From: Sue Howell
Sent: 05 March 2018 11:31
To: Planning.Responses
Cc: David Easton
Subject: RE: Planning Consultation on: Y/92/17/OUT

Comment from Greenspace

Registered: 20th December
 2017
Site Address: Land east of Drove Lane Yapton BN18 0EB
Grid Reference: 497380 103194

Description of Works: Outline application with all matters reserved save access, for up to 300 dwellings, link road, surface drainage, open space and landscaping.
 Departure from the Development Plan and Access route is within the Yapton (Main Road) Conservation Area.

FIGURE 29. Plan showing the green infrastructure strategy for the allocation site

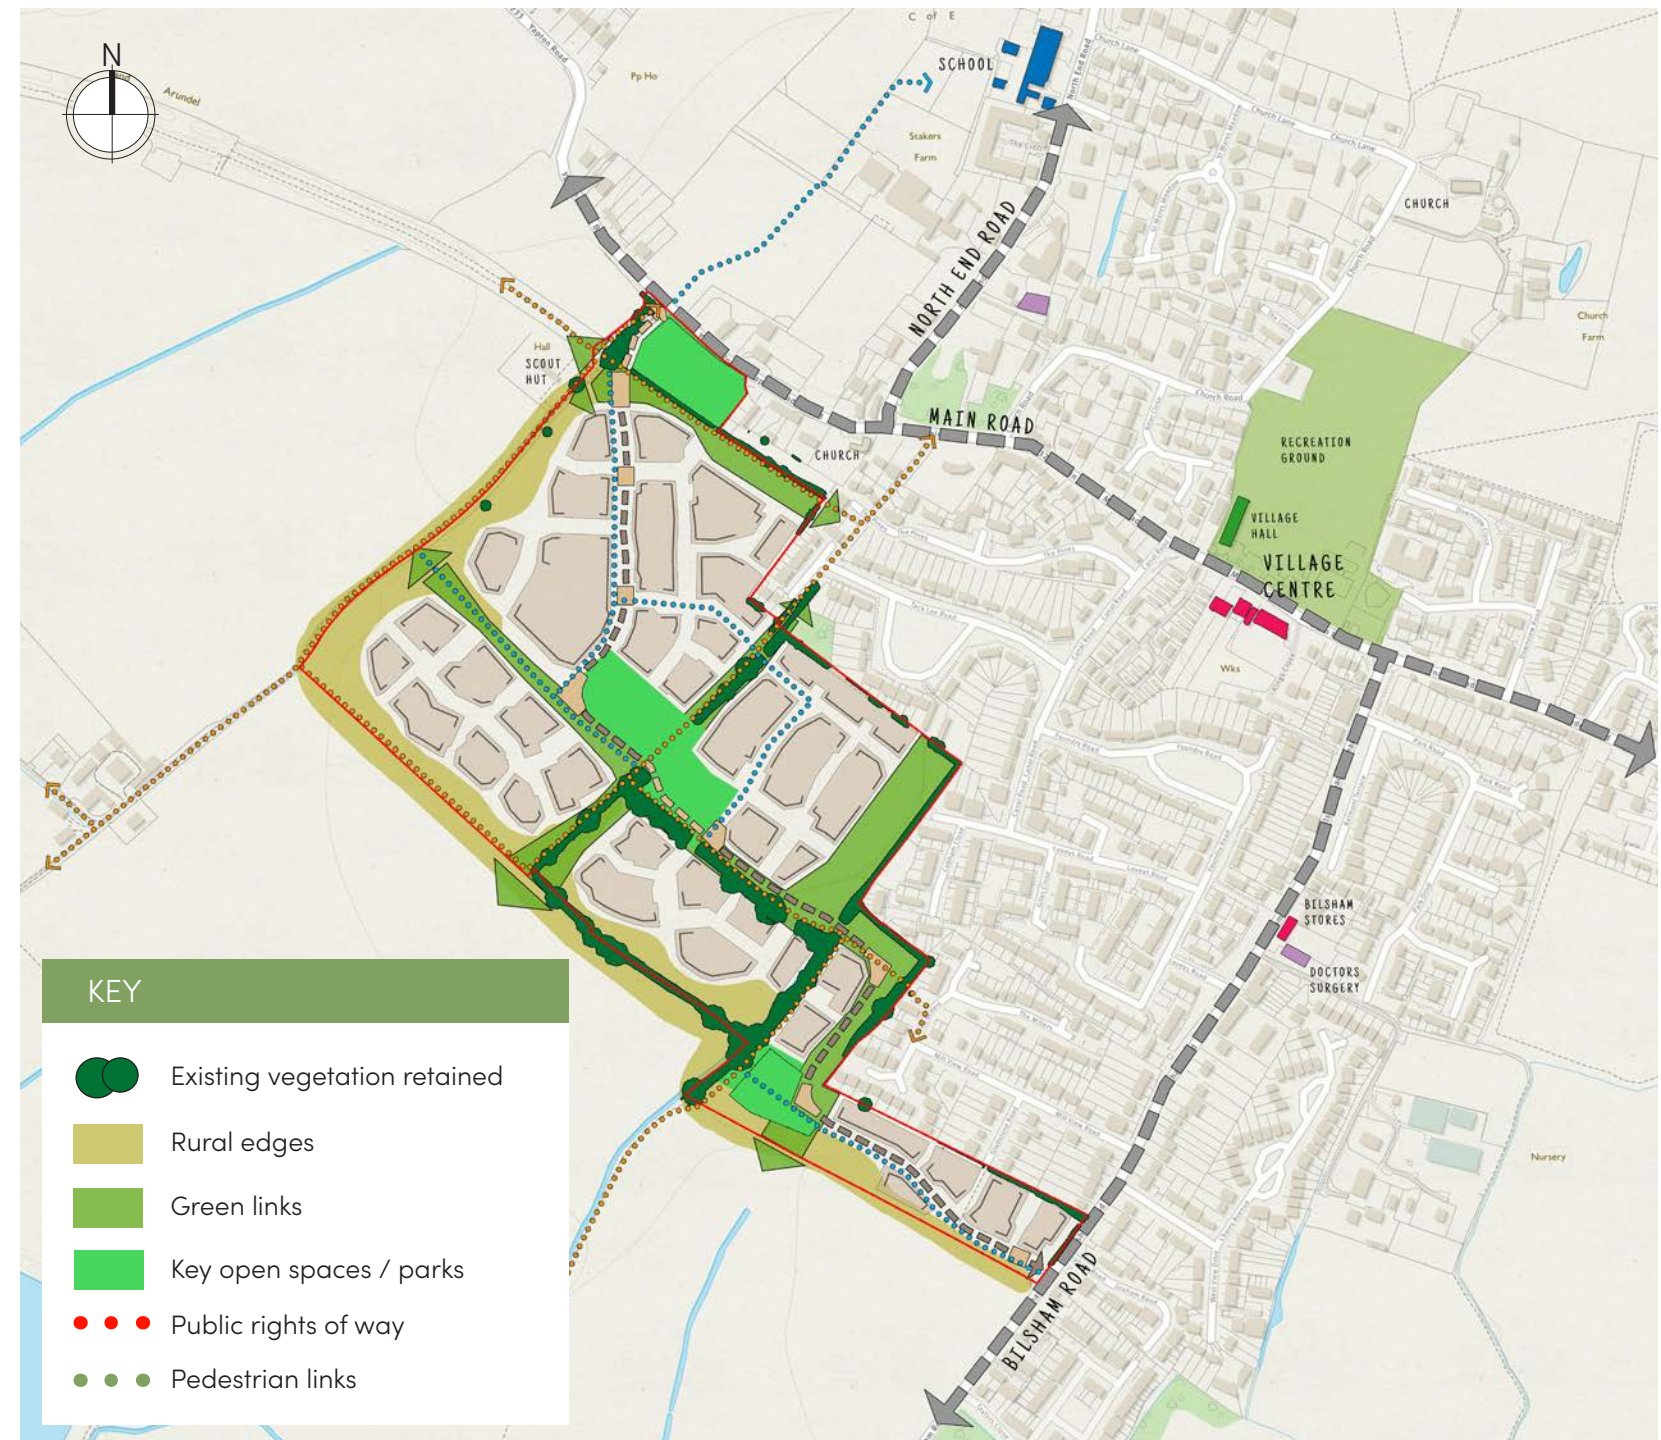
This development proposal is for up to 300 dwellings. **We note that a high proportion of the indicated Open Space areas are detailed as SuDS features. These raise concern as not therefore providing useable Public Open Space in these areas therefore diminishing the POS offer which would appear to being provided within the site.** Confirmation and cross section of these SuDS areas should be provided along with the anticipated timescale that these would be water holding bodies. The full implication of the SUDS within the POS needs to be provided including its future management and maintenance. The recommendation that these are subject to RoSPA or similar organisation inspection should be noted. Indication must be provided as to whether these are likely to be wet or dry areas; this has implications where situated near to residents and play areas. Where they are to remain wet for long periods their safety in must be assessed regarding the close proximity to these large residential areas. Any such SUDS features including swales, wet balancing ponds, reed beds and wetland areas should be designed as beneficial wildlife, amenity and landscape features as incorporated as part of an open space or landscaping scheme for the development.

The masterplan layout shows accessibility to the larger areas of open space particularly to the periphery – however as stated above the usability of these would now be in question because of the extensive SuDS now shown in these areas. Some corridor linkage has been considered, however the primary area of useable POS shown to the north of the development does not provide connecting greenspace and park/ amenity/ children's play space. POS and green corridor should be integrated within and around the development and safely accessible to residents.

- Confirmation of POS and play offer to be provided particularly in relation to the areas now shown for SuDS provision
- Siting of the LEAP and LAPs and associated facilities needs to be shown in detail.
- Buffer areas and wildlife habitat zones along with tree protection details for those trees to be retained to be provided.
- Indication of future management proposals to be provided

FIGURE 47. Application site plan

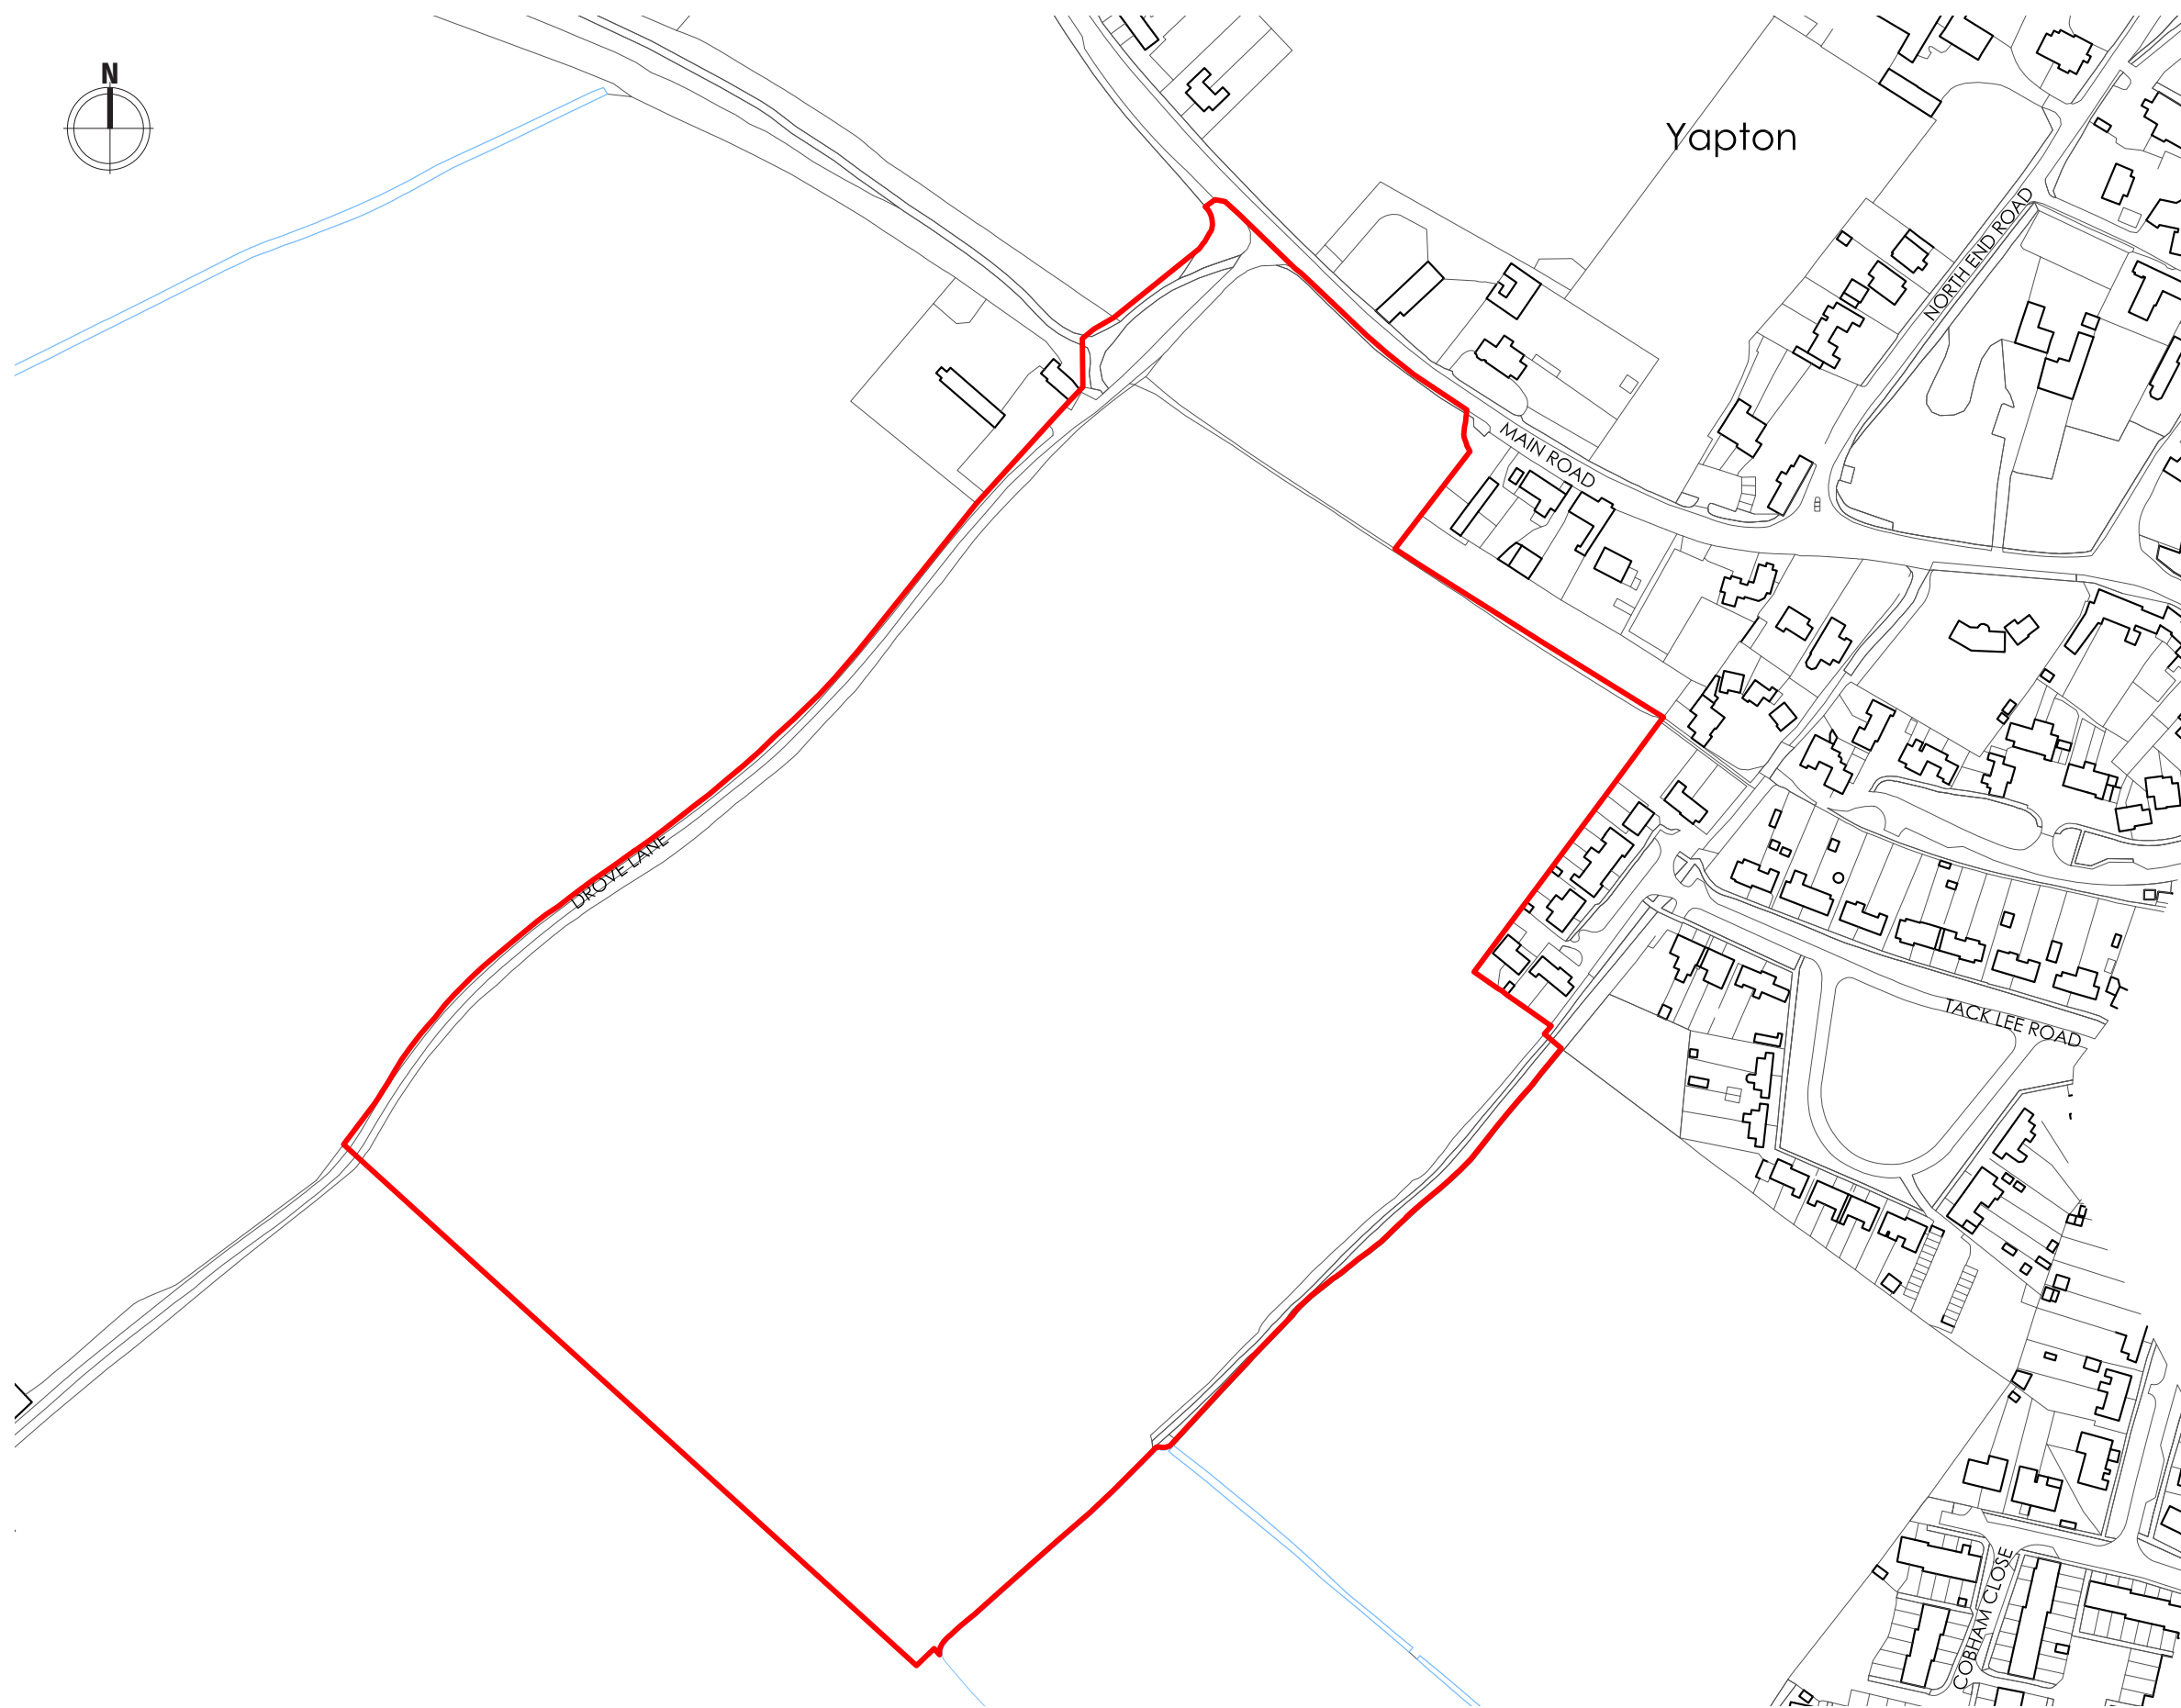
Provision of LAP, LEAP, MUGA (Multi-Use Games Area) and NEAP-contribution would be sought on site, with confirmation of play provision being provided to be submitted and approved. The LEAP location is indicated, but no provision of LAPs which would also be required presently shown within

the masterplan. The indicative layout for the LEAP is integrated centrally within the development where it could provide connectivity with existing residential surrounds.
